PROJECT REFERENCE NO.	SHEET NO.
R-5021	UC-12
DESIGNED BY:	10/29/2021
DRAWN BY:	
CHECKED BY:	
APPROVED BY:	
REVISED:	
NORTH CAROLINA DEPARTMENT OF TRANSPORTATION	
UTILITIES ENGINEERING SEC.	
PHONE: (919) 707-6690	
FAX: (919) 250-4151

UTILITY CONSTRUCTION

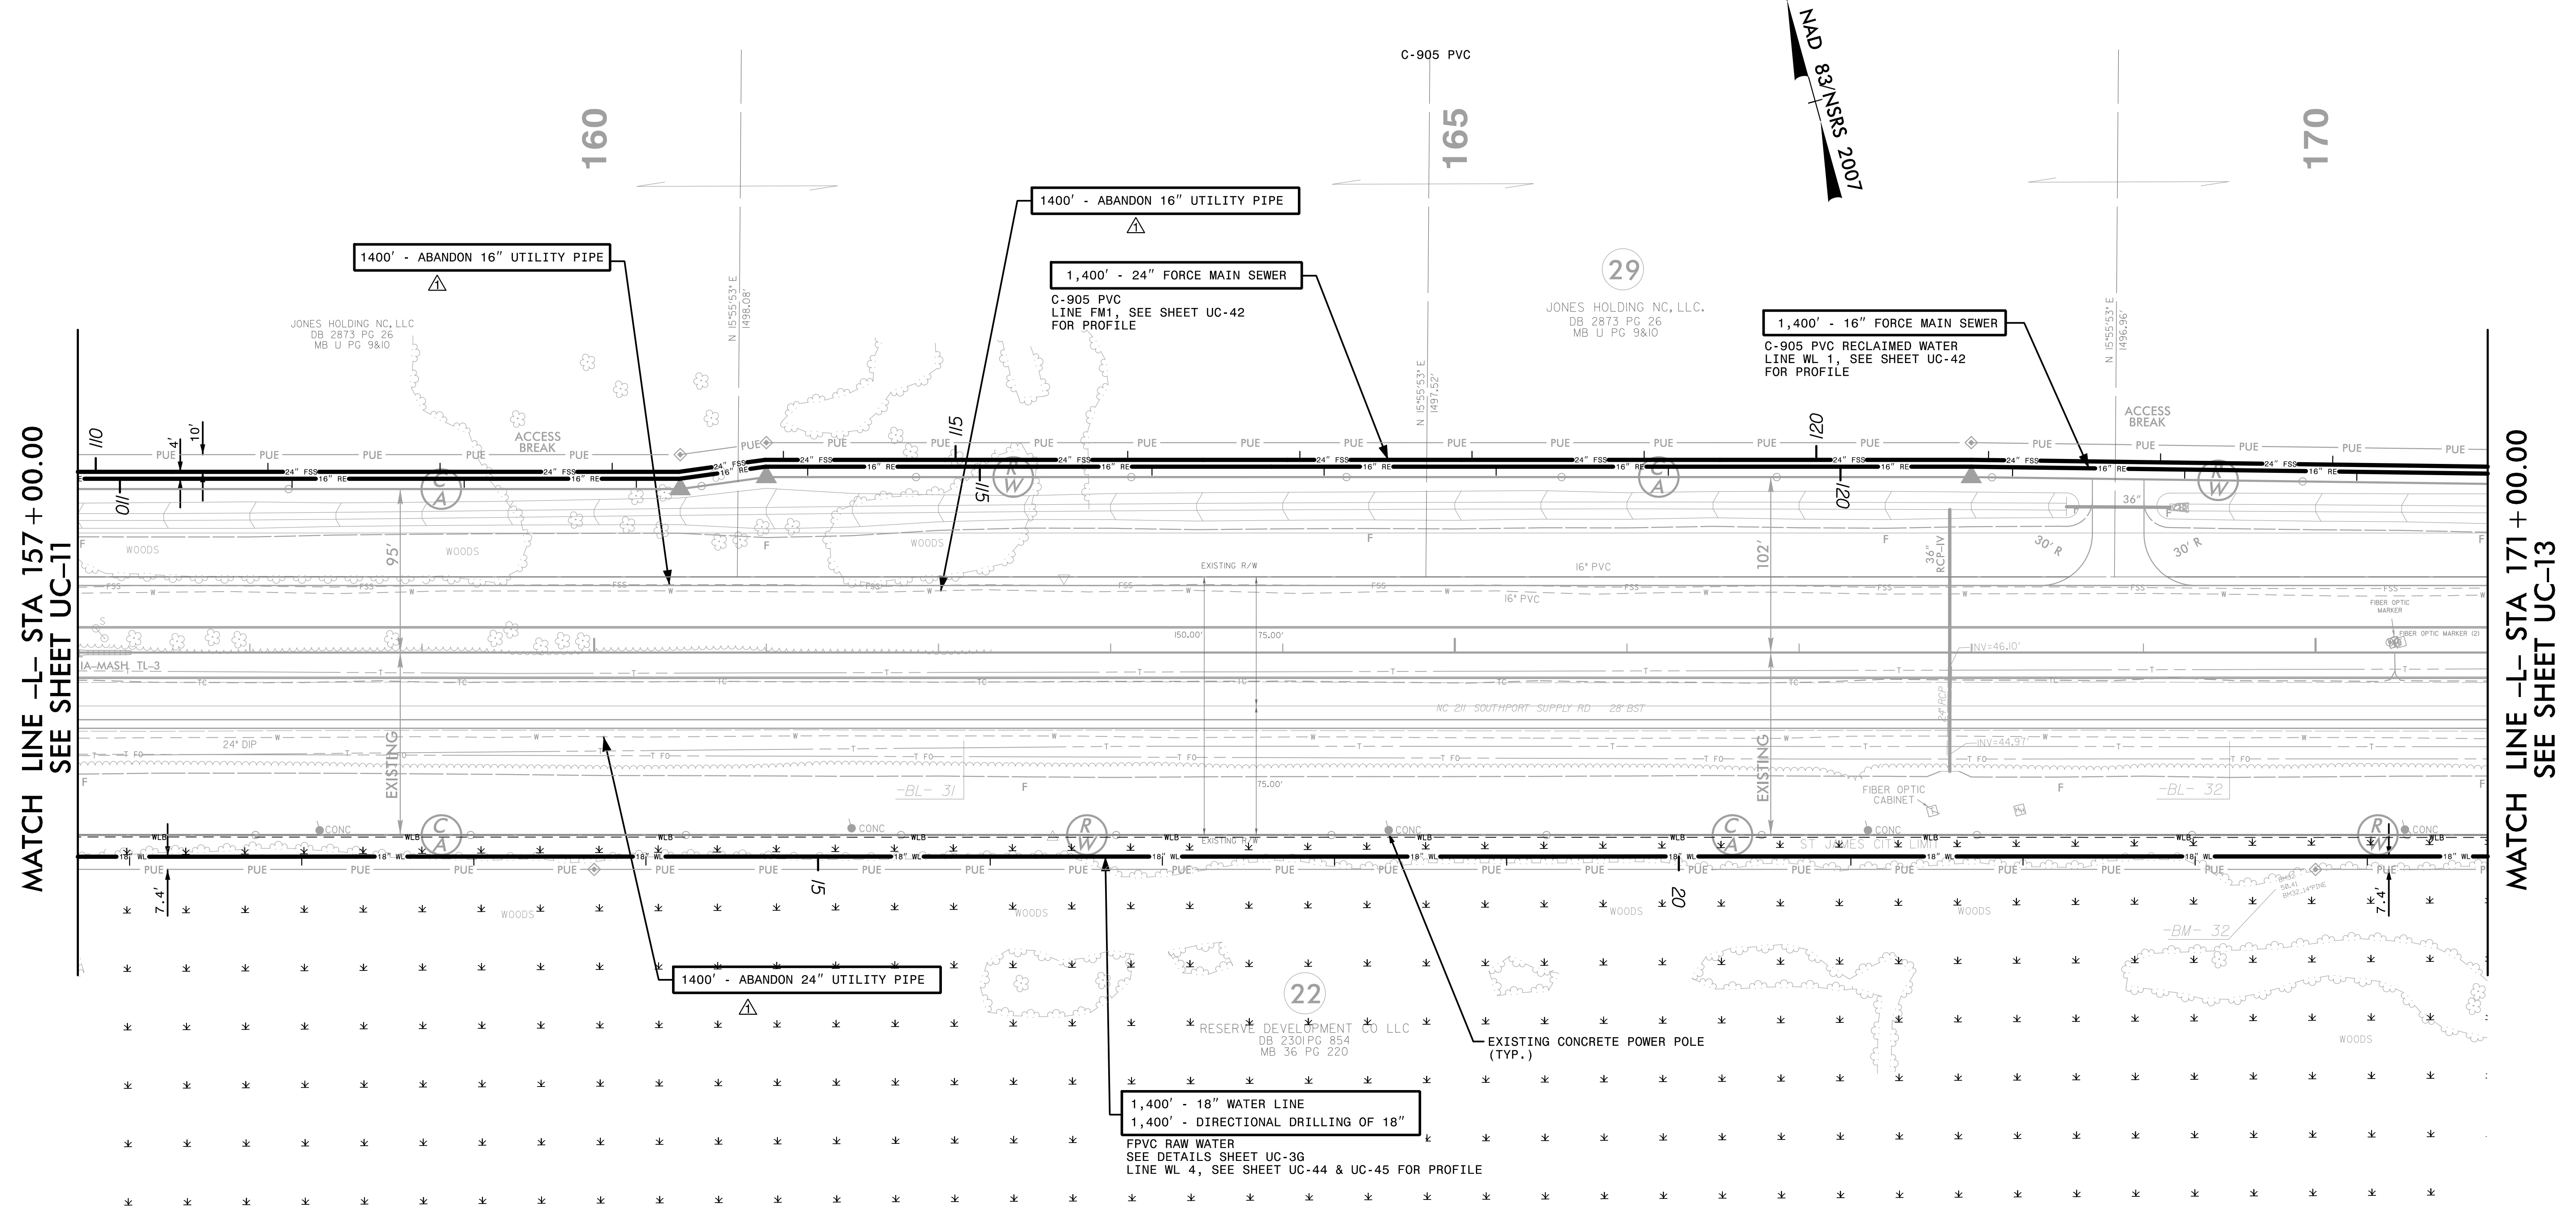
△ REMOVED NOTE BELOW PAY ITEM FOR ABANDON UTILITY PIPE PER ADDENDUM NO. 1
